**Planning Department
Transportation Development Services**

**Re: Broadstone Cottonwood, 10800 Cibola Loop
Clubhouse, Fitness Center, Pool Area and Buildings 3 and 4
Submittal for Certificate of Occupancy – Transportation Development
Administrative Amendment dated 01-22-13 (A13-D022)
Certification dated 09-26-14**

# A1.10

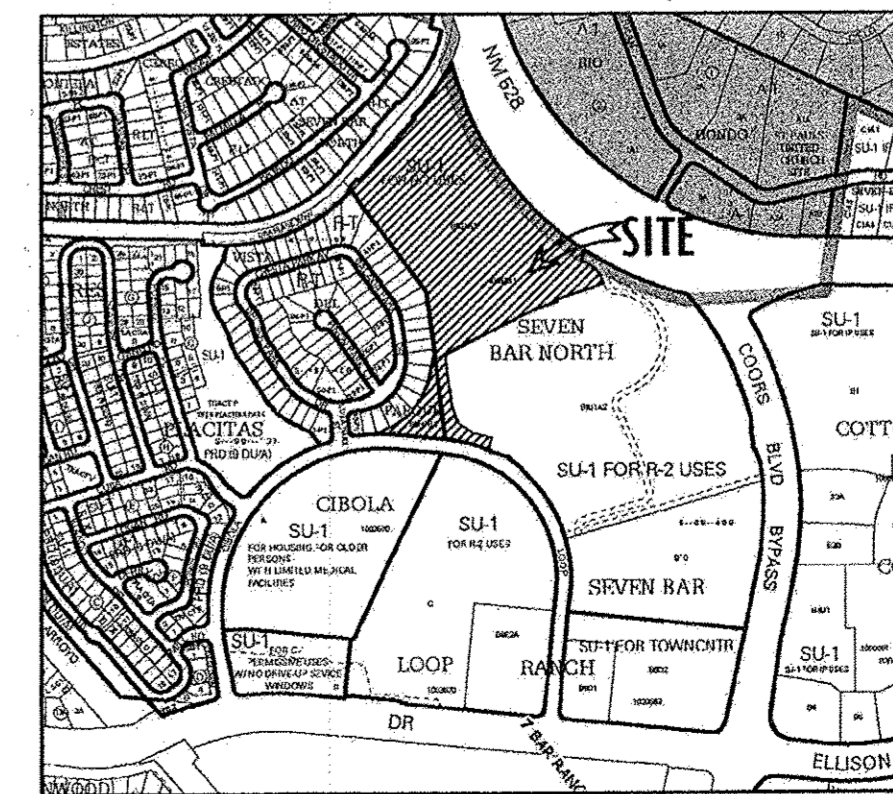
- The curb built near the ADA parking south of the Rec/Office has created a tripping hazard. Please remove and add curb bumpers in the parking spaces.
- Please provide a phasing plan that clearly shows the building numbers and the sequence of submittals.
